REQUEST

Current Zoning: R-17MF(CD) (multi-family residential, conditional)
Proposed Zoning: R-22MF(CD) (multi-family residential, conditional)

Approximately 4.2 acres located on the east side of West W.T. Harris Boulevard, north of Interstate 485, and south of Mt. Holly-Huntersville Road.

SUMMARY OF PETITION

RZ1.00

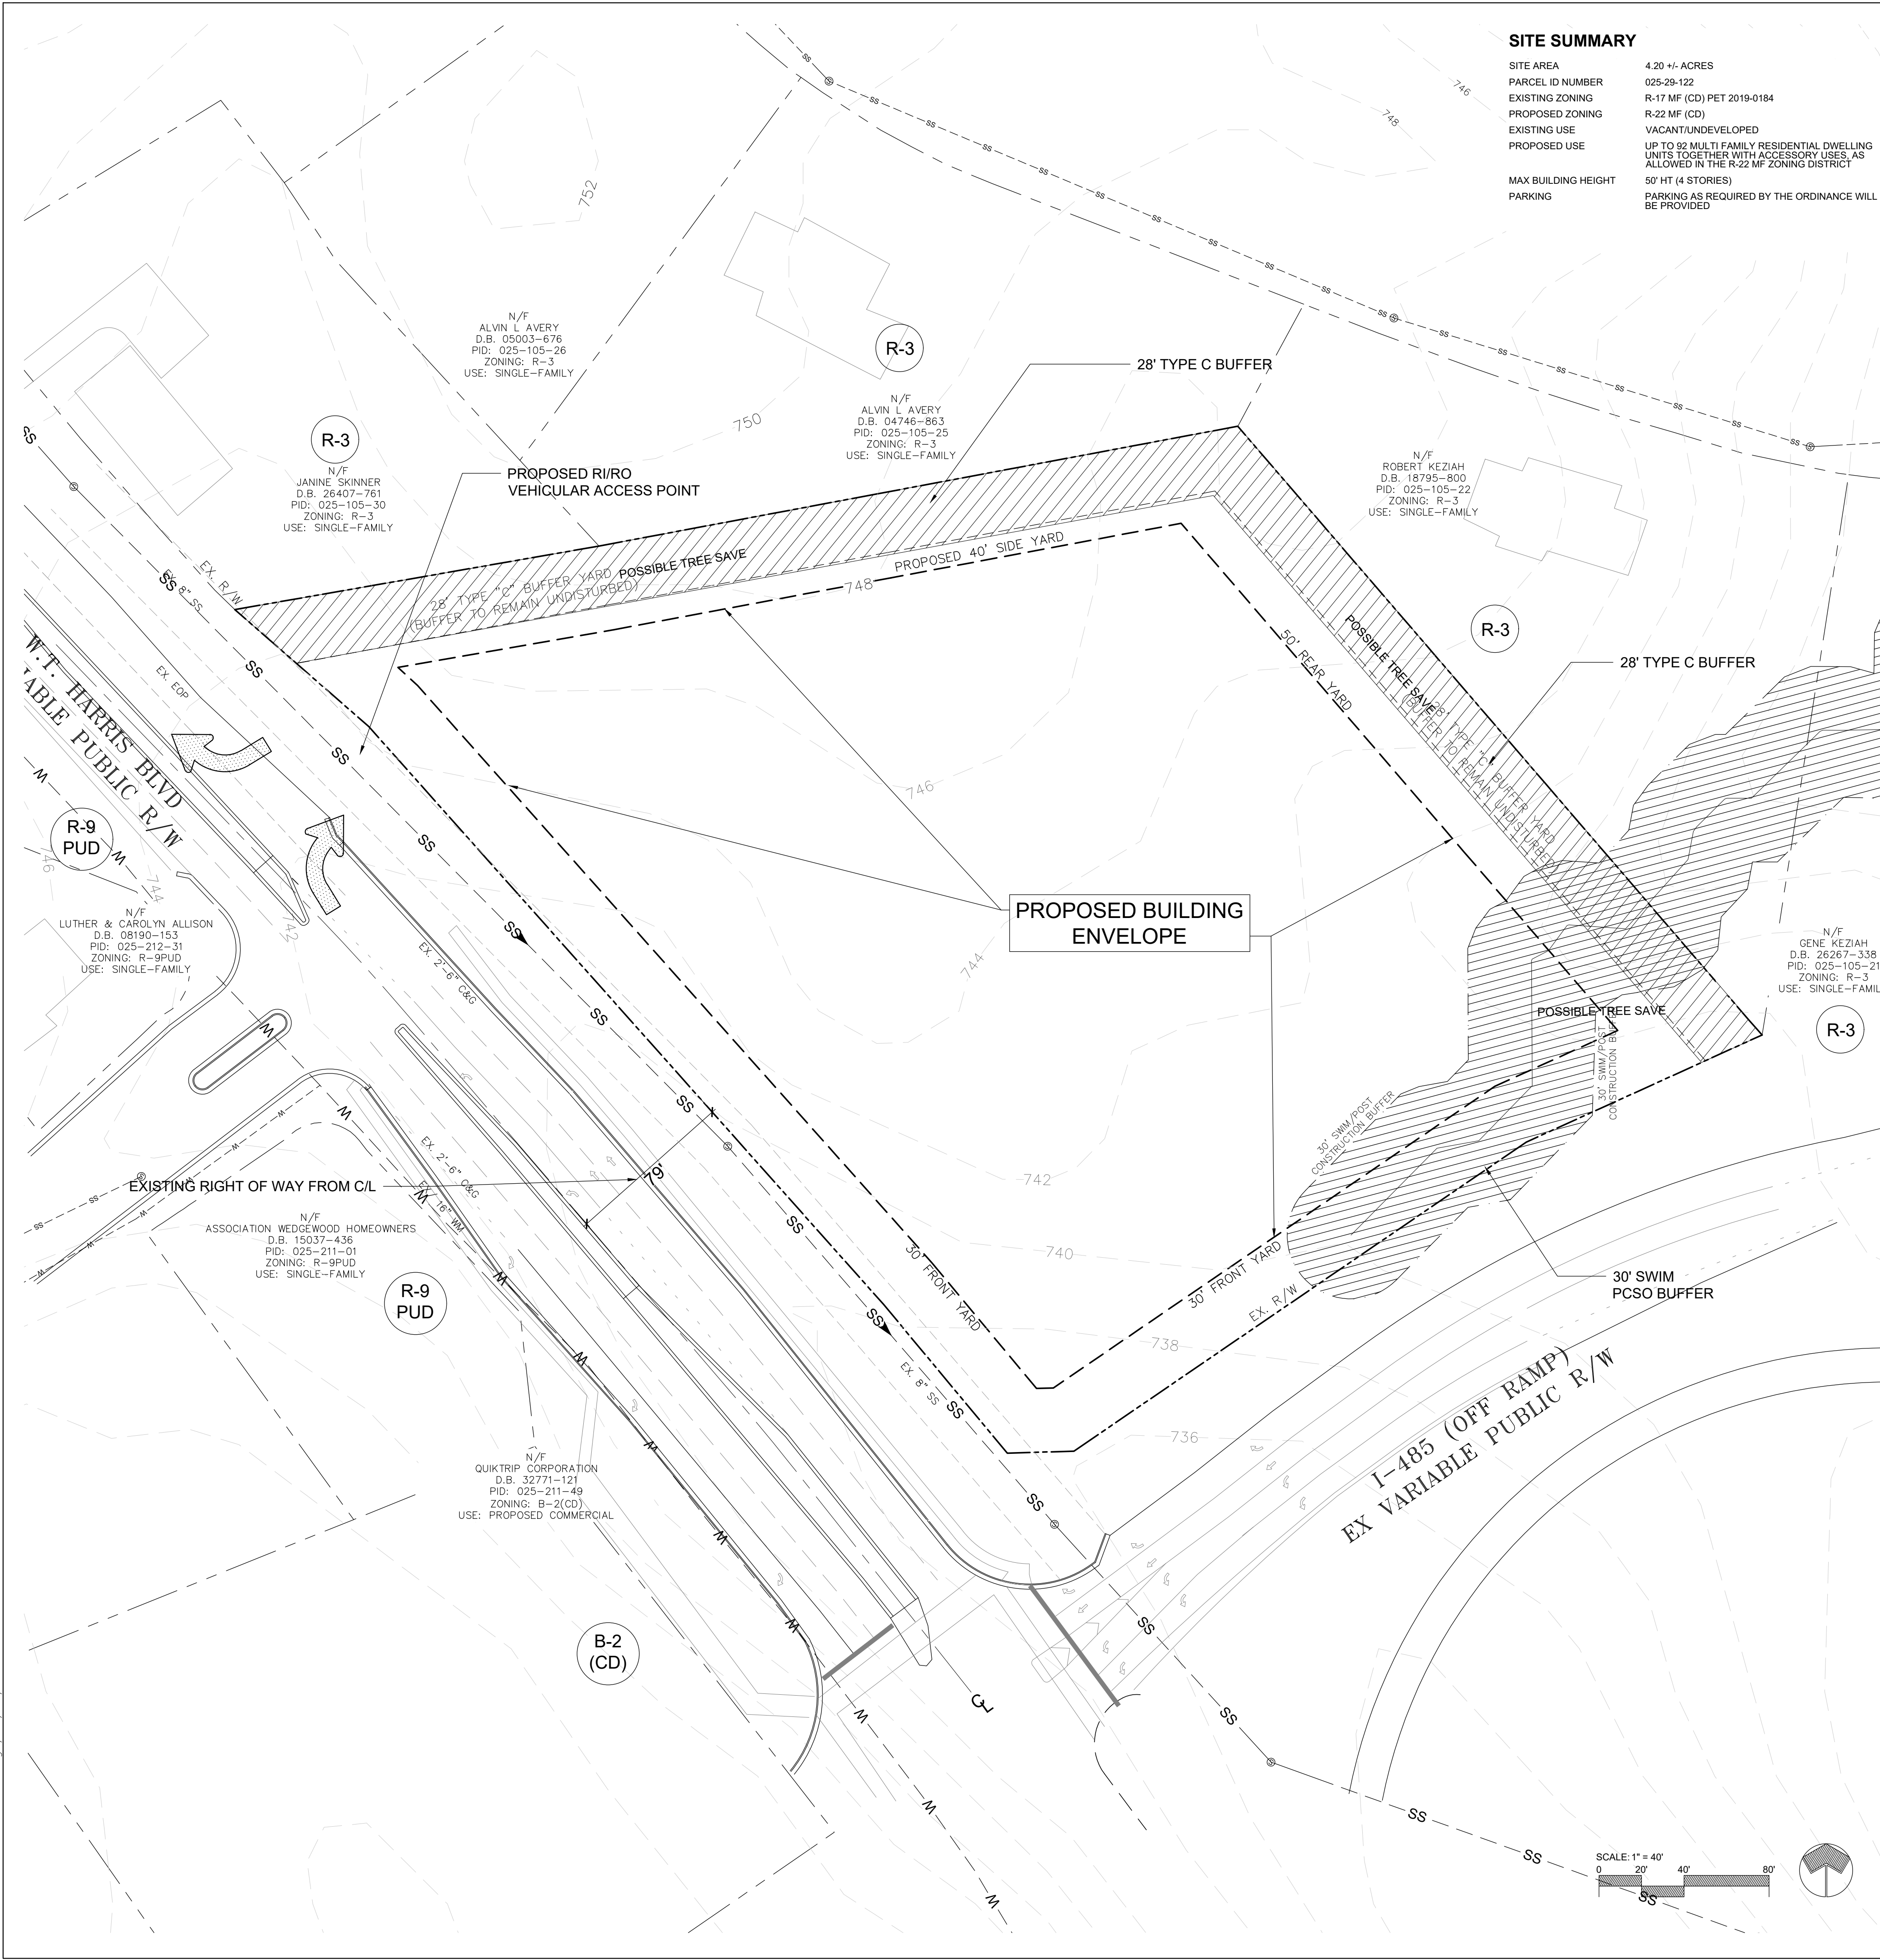
- ~~3. Increased yards will need to be provided per the ordinance for the increased height abutting single family residential zoning.~~ **Addressed**
- ~~4. Development Note D.1. proposes two principal buildings, but one building is illustrated on the site plan. Please ensure information is consistent.~~ **Addressed**

RZ2.00

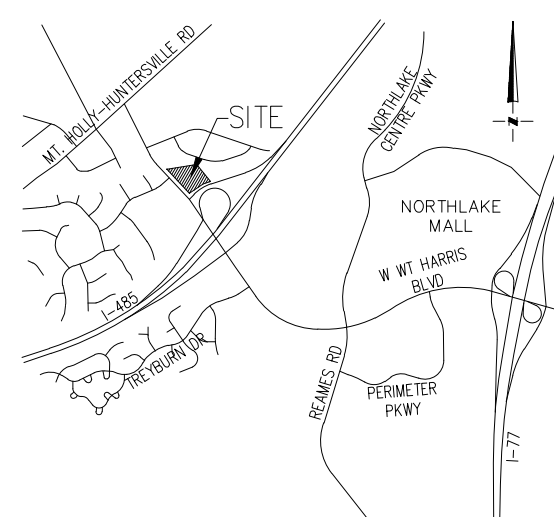
- ~~1. Label and dimension curb and gutter on the site plan.~~ **Addressed**
